East Pye Solar
Statement of Common Ground: South Norfolk
District Council

Revision 1
October 2026

Planning Inspectorate Reference: EN0110014
Document Reference: EN0110014/EXAM 9.5
Rule 8(1)(e) Infrastructure Planning (Examination Procedure) Rules 2010

VL : View Location
 CRC : Cable Route Corridor
 BESS : Battery Energy Storage Systems

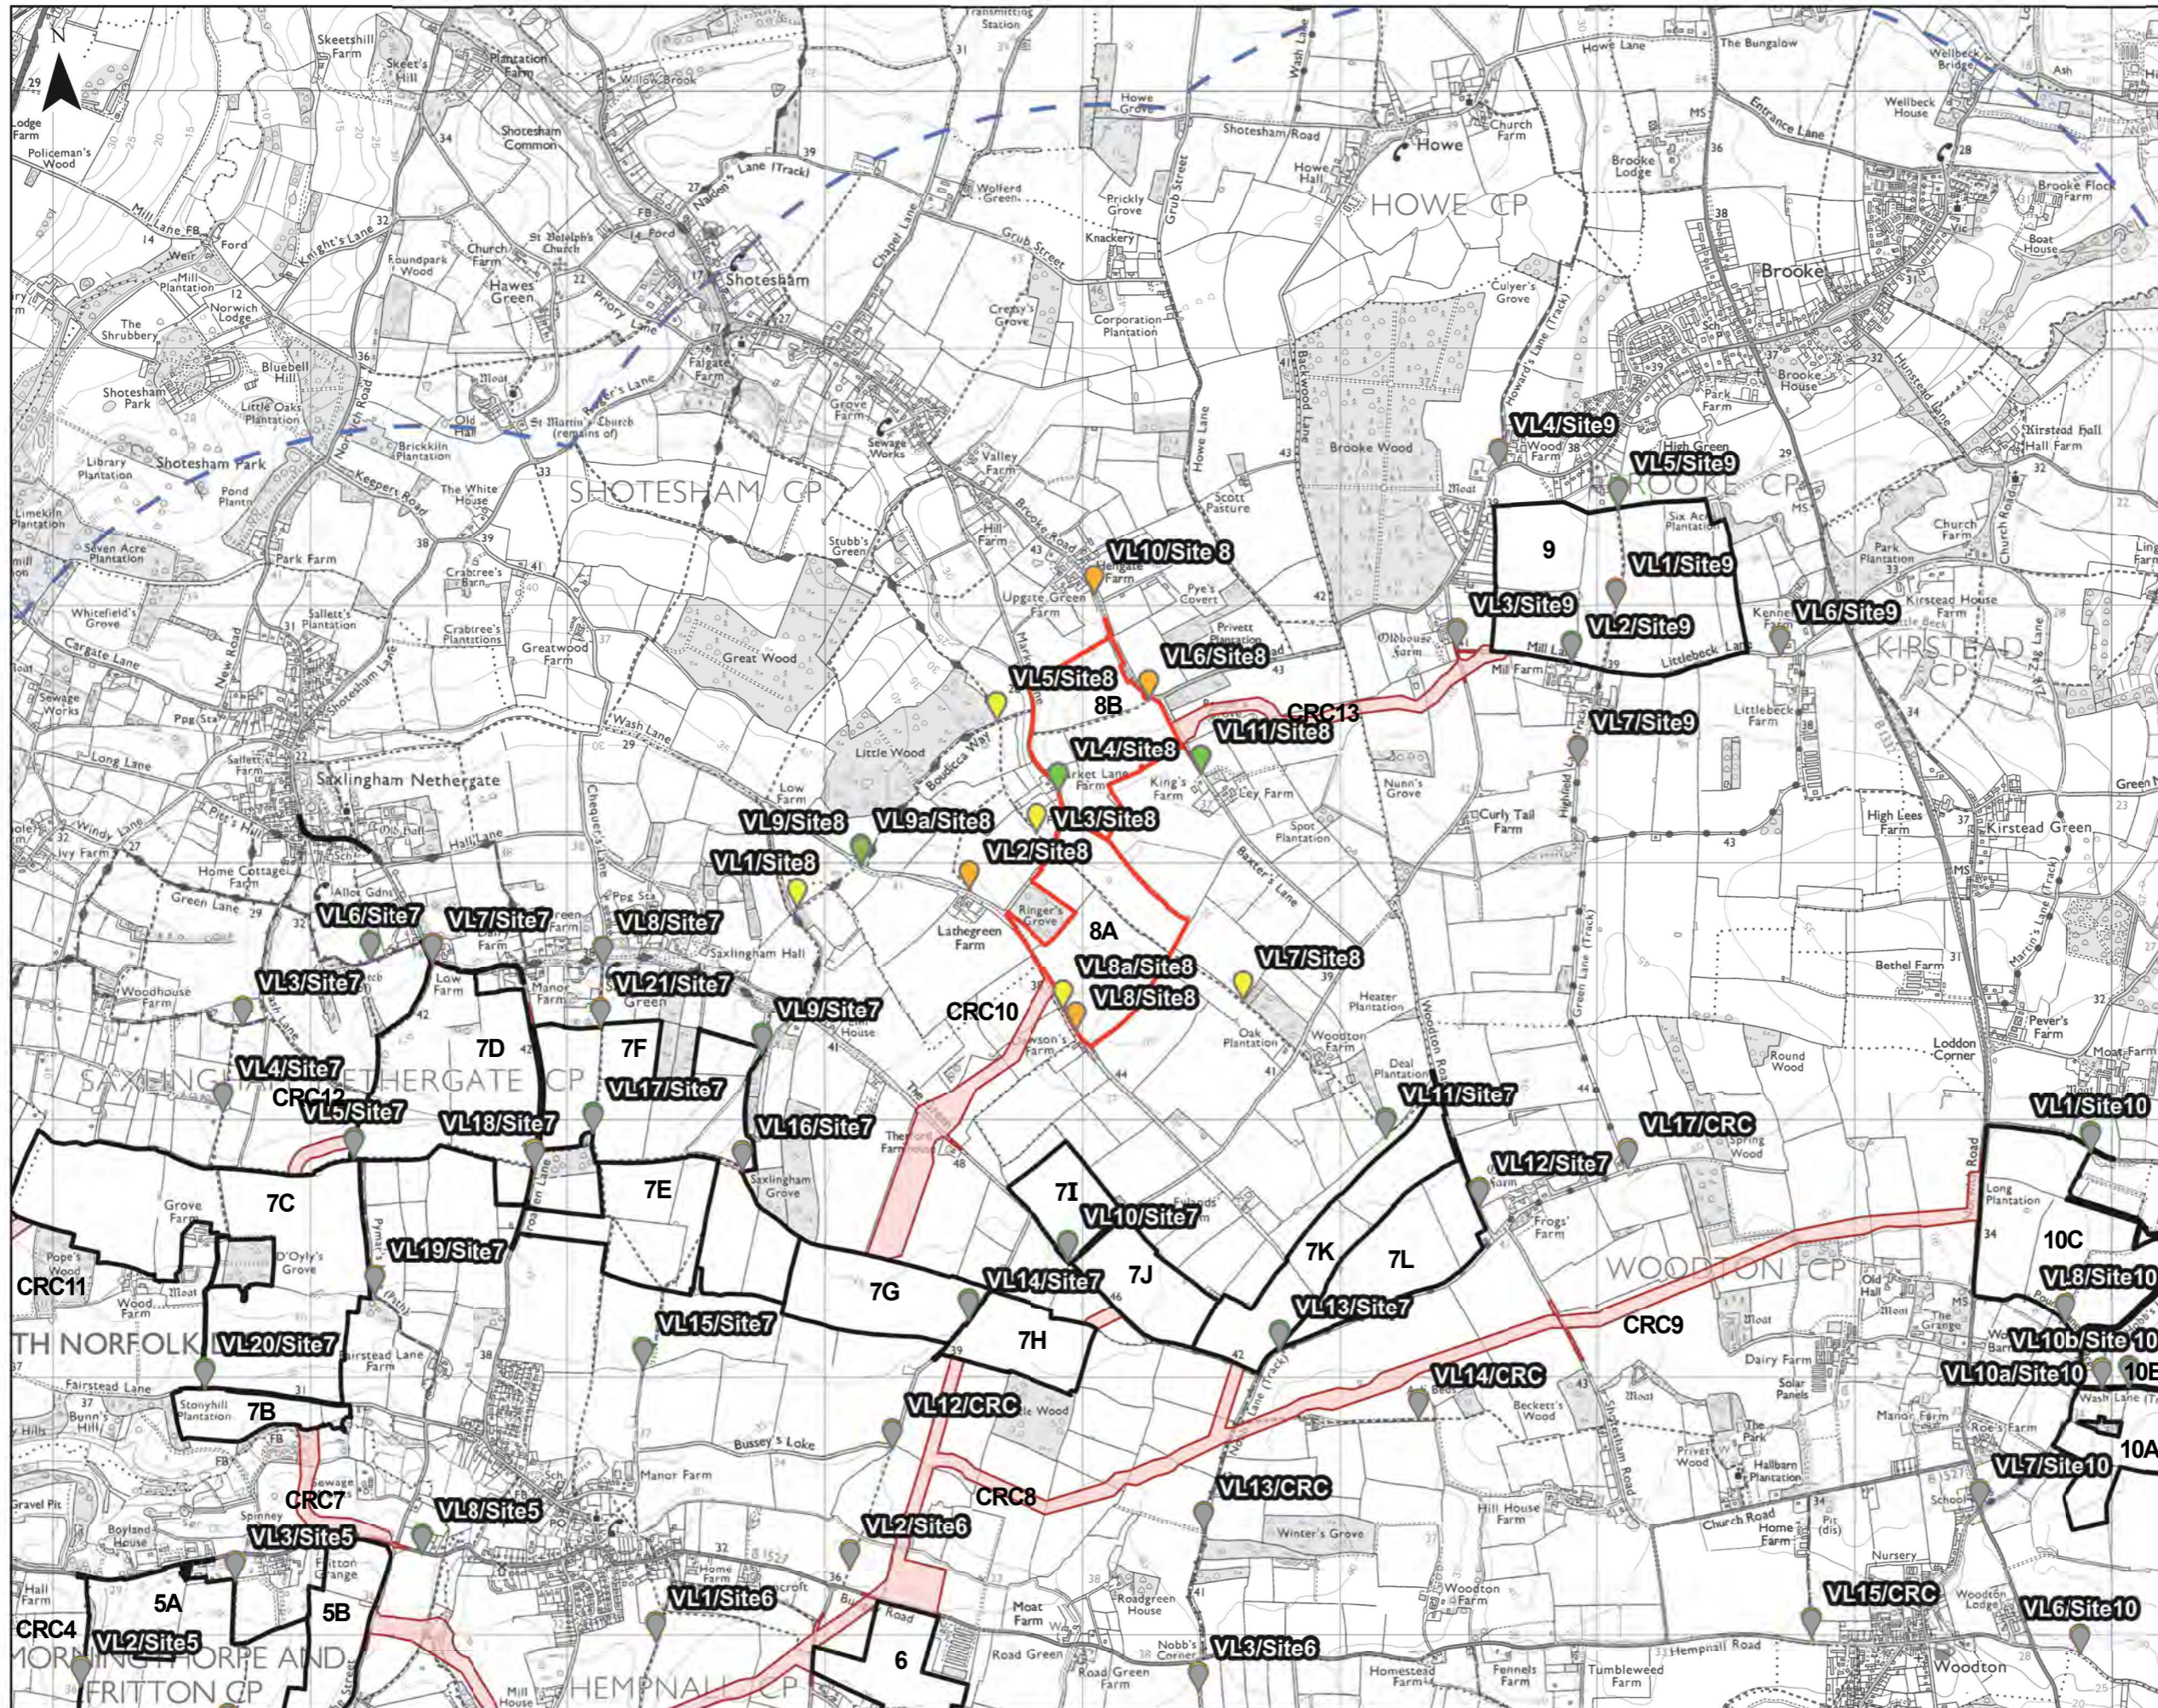
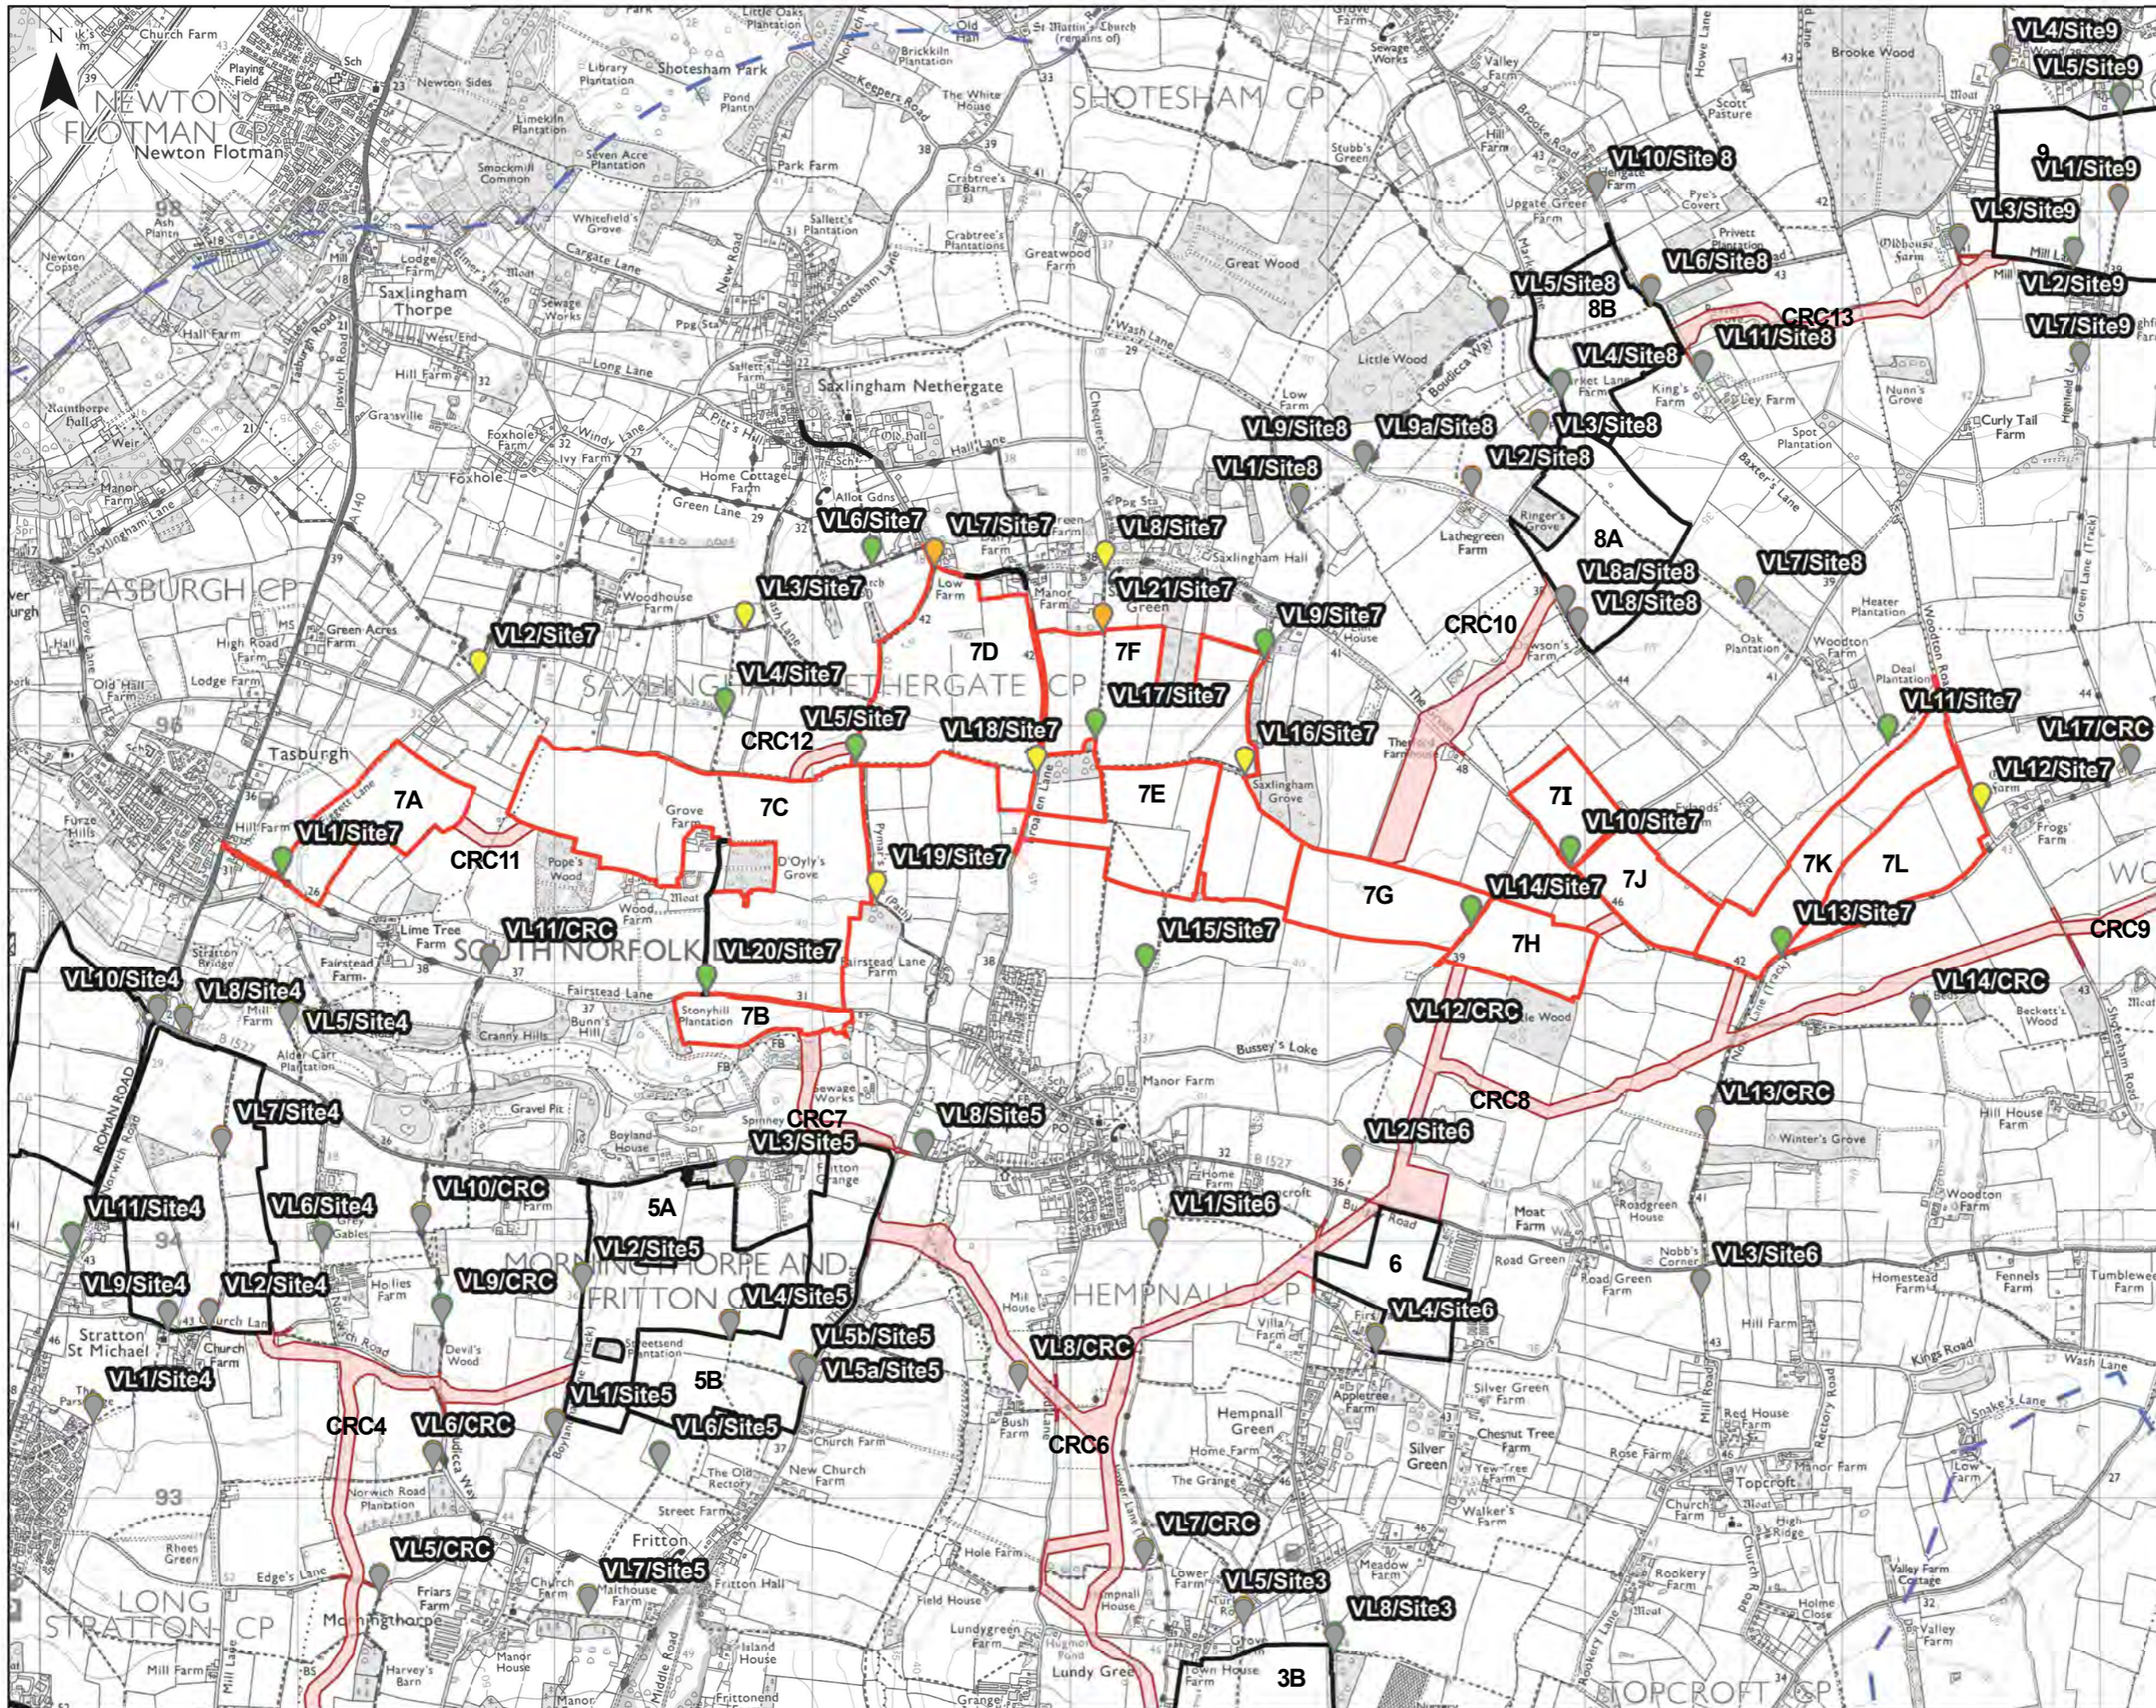
SNDC LV - 8	Scope View Location selection	ES Volume 1, Chapter 7 - Landscape and Visual [APP-043] ES Volume 2, Figure 7.7 - View Locations and Visualisations [APP-082]	The Applicant consulted with SNDC to agree view locations, and SNDC is content with the submitted materials.	The Applicant has undertaken consultation with the Landscape Officer in respect of the selection of assessment view locations. In response to comments received, a number of additional view locations have been incorporated into the assessment, including: VL8/Sub, VL8/LP2, VL7/LP3, VL8/LP3, VL9-VL12/LP4, VL7/LP5, VL9-VL11/LP8, VL7/LP9, VL10/LP10, VL16 and VL17/CR.	Agreed

SNDC LV – 10	Scope Visualisation for Landscape and Visual Assessment	ES Volume 1, Chapter 7 - Landscape and Visual [APP-043] ES Volume 3, Appendix 7.1 - Landscape and Visual Methodology [APP-118] ES Volume 2, Figure 7.7 - View Locations and Visualisations [APP-082]	SNDC agree that the submitted visual technical visualisations cover a reasonable number of viewpoints and locations however they should have been prepared as Type 4, not Type 3, to guarantee an appropriate level of accuracy for such complex and sensitive development.	The Applicant has consulted with the Landscape Officer in respect of the location and type of visualisations to be produced, but no response was received. The location and type of visualisations are illustrated in ES Volume 2, Figure 7.7 - View Locations and Visualisations [AS-009]. The methodology for visualisation production is set out in ES Volume 3, Appendix 7.1 - Landscape and Visual Methodology [APP-118]. The visualisations have been prepared in accordance with industry-standard guidance, specifically the Landscape Institute [2019] Visual Representation of Development Proposals Technical Guidance Note 06/19 [TGN 06/19]. The types of visualisation produced include: • Photowires [LI TGN 06/19 Type 3]; • Photomontages / Photowires for Winter Year 1 [LI TGN 06/19 Type 3] with no landscape measures shown; and • Photomontages Summer Year 15 [LI TGN 06/19 Type 3] with established landscape measures shown. The parties will continue discussions regarding the requirement and potential locations of Type 4 visualisations.	Under discussion

Reference	Matter Topic	Document Reference of Matters	Consultee Position	Applicant's Position	Status
				The view locations presented within ES Volume 1, Chapter 7 - Landscape and Visual [APP-043] and ES Volume 2, Figure 7.7 - View Locations and Visualisations [APP-082] are therefore considered to provide an appropriate and robust basis for establishing baseline landscape and visual conditions.	
SNDC LV-9	Scope View Location Selection	ES Volume 1, Chapter 7 - Landscape and Visual [APP-043] ES Volume 2, Figure 7.7 - View Locations and Visualisations [APP-082]	Following a review of the submitted documents with the DCO, SNDC consider that additional viewpoints from the Via Beata, Boudicca Way, and from footpaths within the sites or on the site's boundaries would be beneficial to illustrate worst-case scenarios and the extent of change for sensitive visual receptors and the suggested locations are listed in SNDC's Local Impact Report.	This matter will remain under discussion until SNDC's Local Impact Report is received.	Under Discussion
